25 March 2026

Our Ref: 2026/152579
File No: R/2018/33/C

Advice on Modification – Sydney Opera House Lower Concourse – SSD-9794 - Mod 1

DRAWING NO.
DA.131

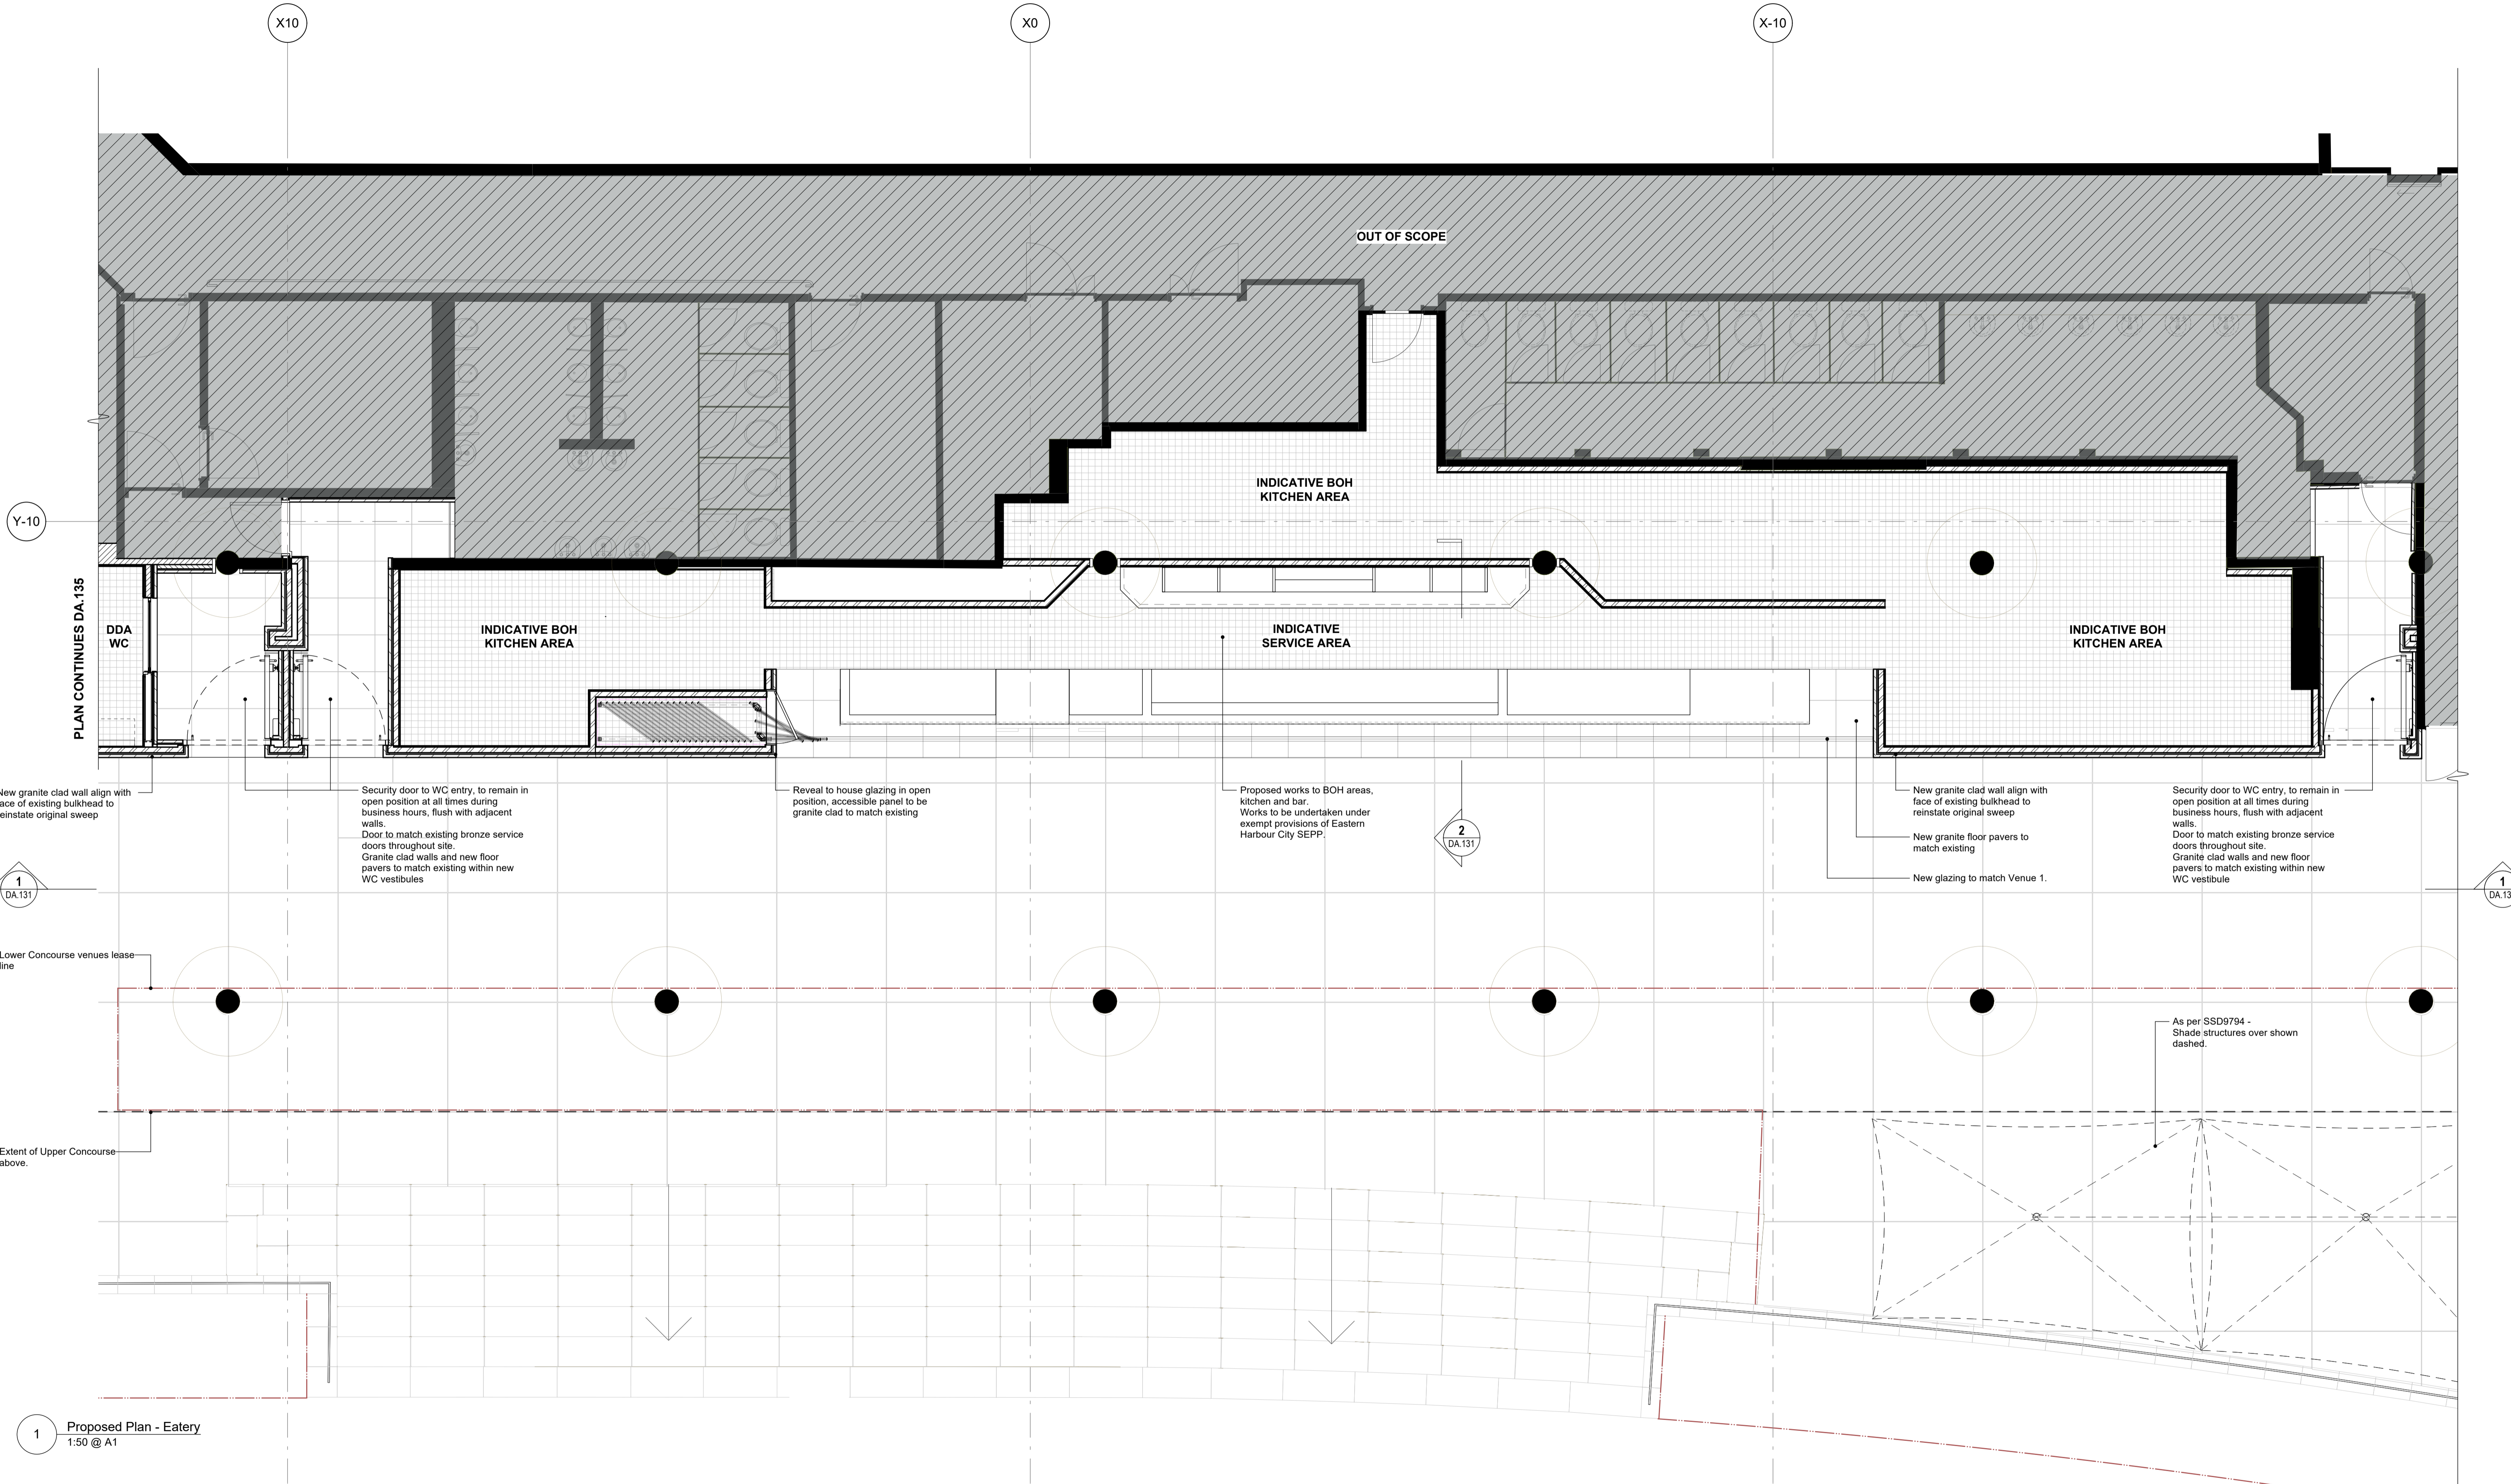
The proposed plans show Venue 2 and the accessible toilet partition walls intersecting with the existing mushroom columns. The City does not support this approach. It is considered that any new partitions should be clear of the mushroom columns, including their capitals (which is the outcome demonstrated for Venue 1).

This issue is also identified in the submitted Heritage Impact Statement (HIS) and conditions prepared by Design 5 Architects. Where partitions are required to intersect the columns, the conditions recommended within the HIS requiring further exposure of the mushroom columns and conjunction details with heritage walls, are supported.

1 Plan - DDA Amenity
1:25 @ A1

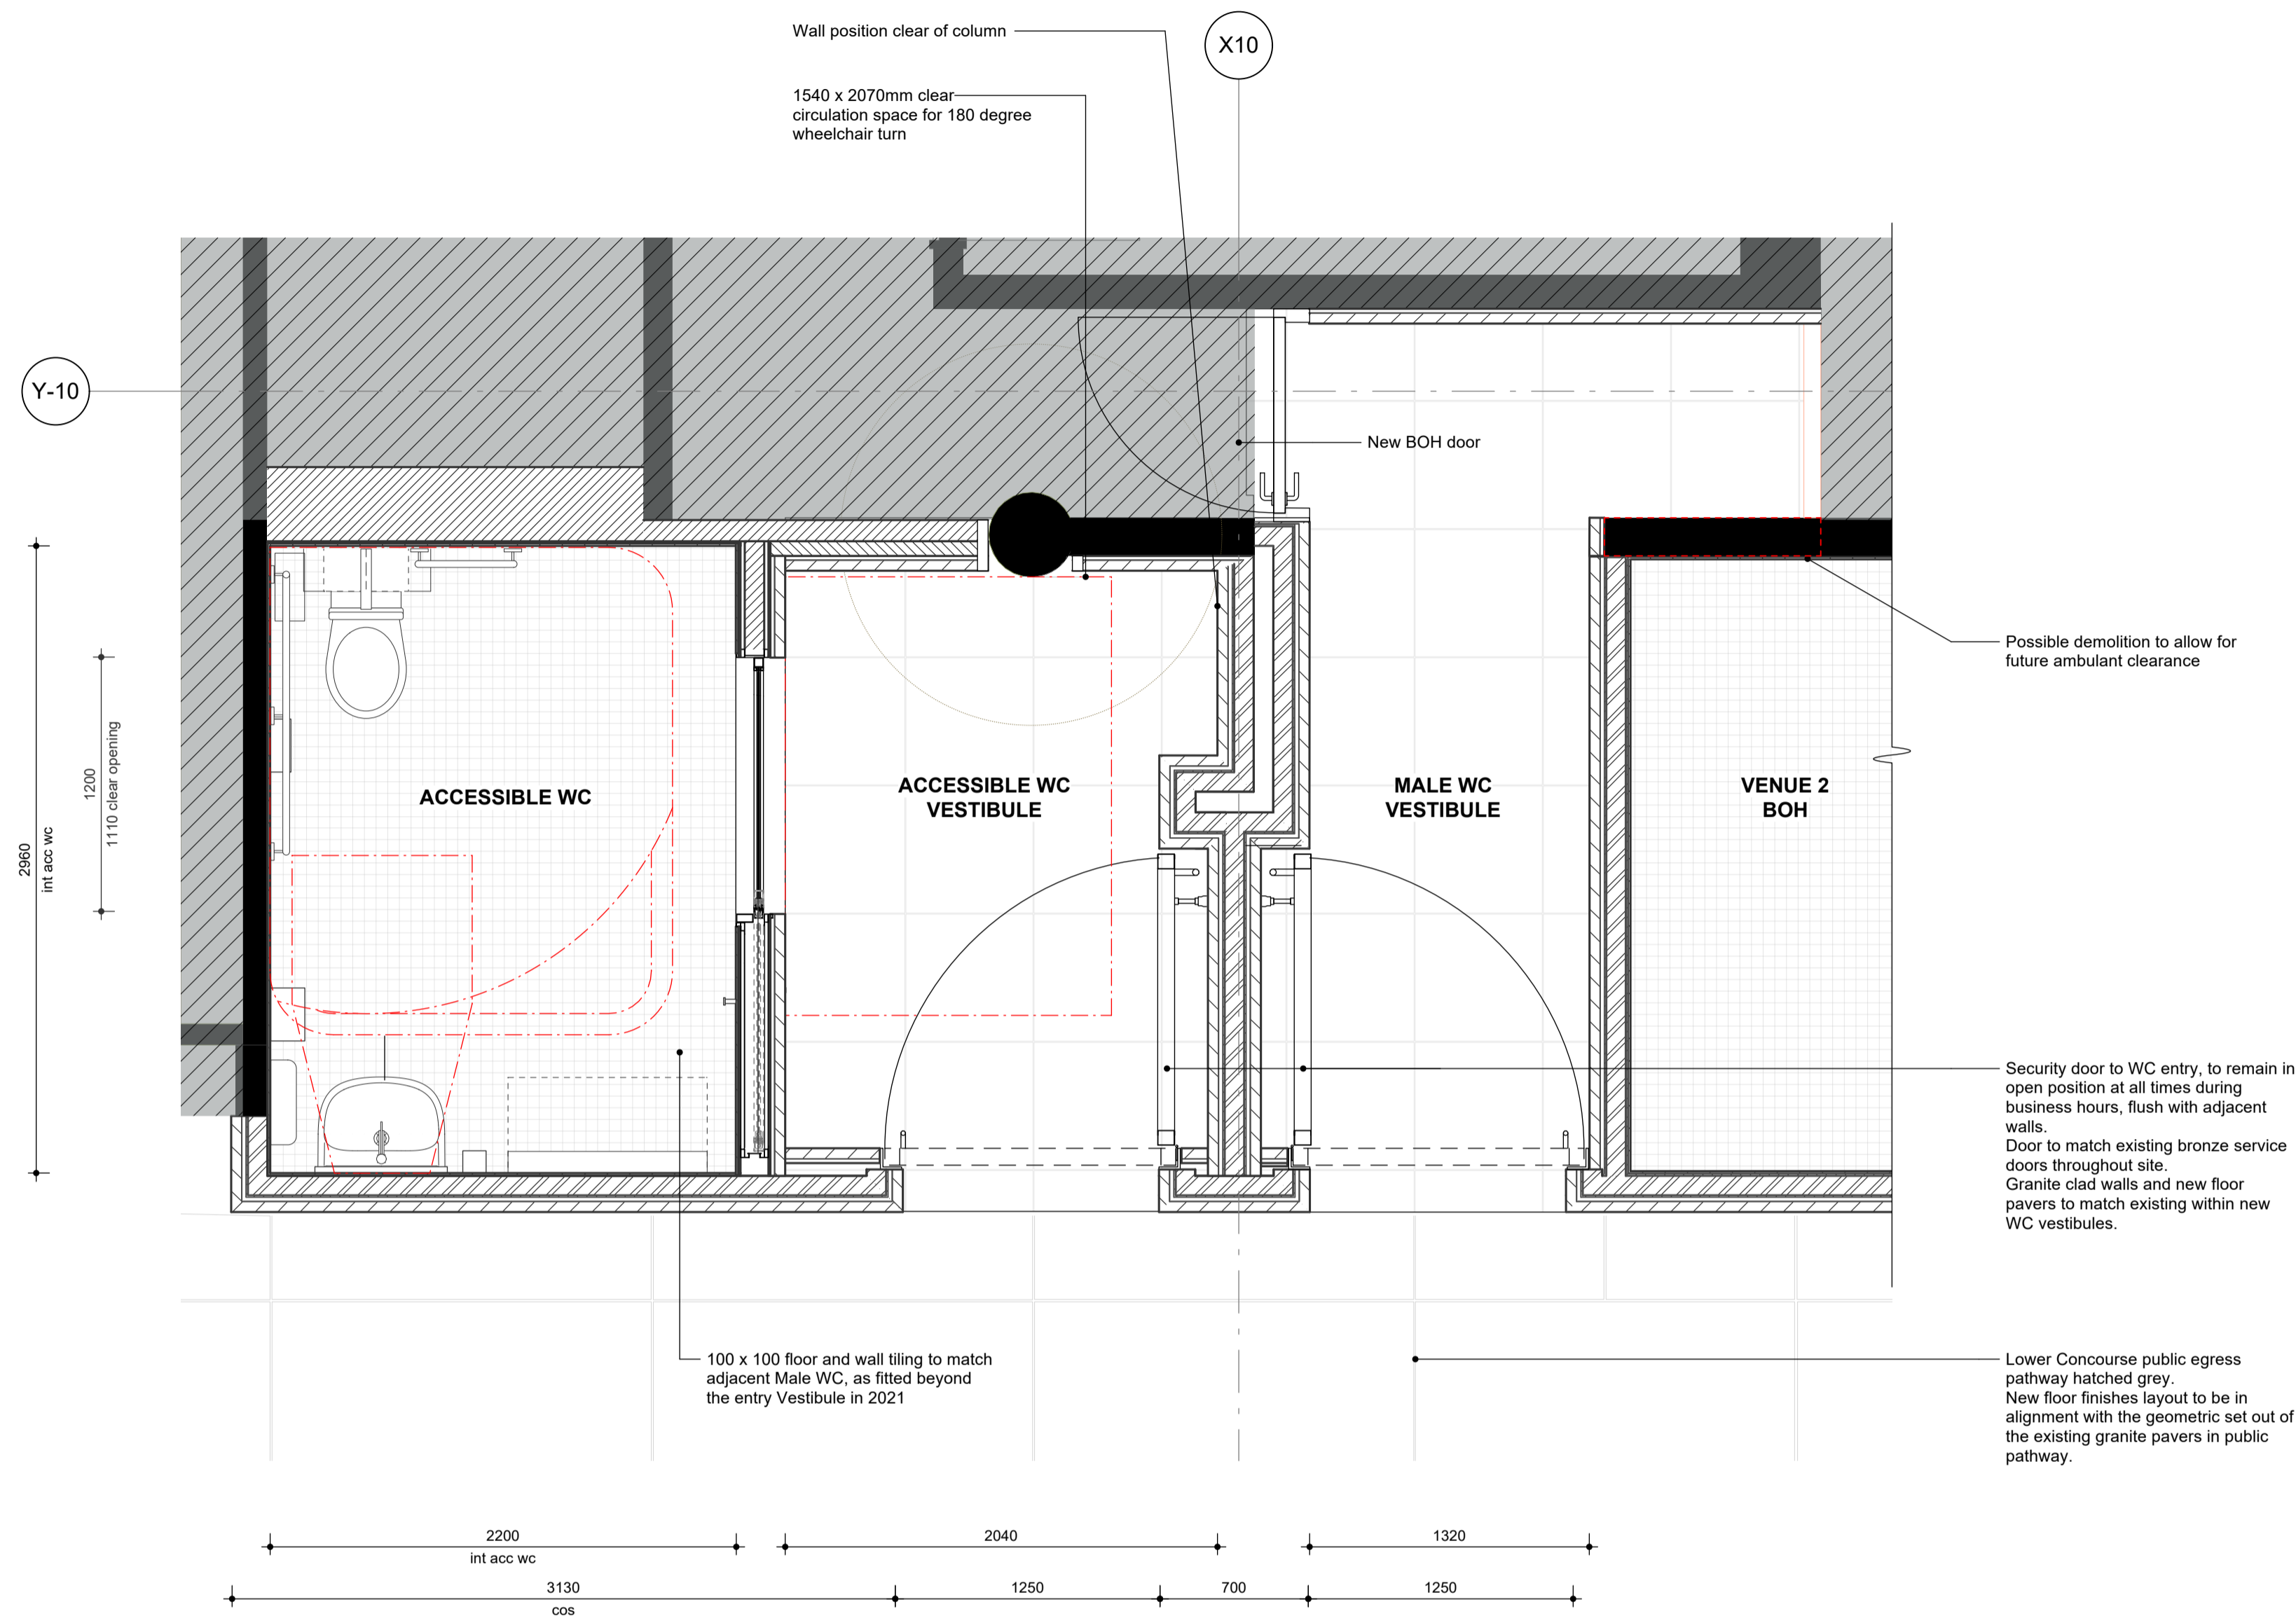
An accessible toilet has been provided in accordance with Condition B33 of the consent. It is recommended that wheelchair manoeuvrability and turning should be demonstrated on the drawings.
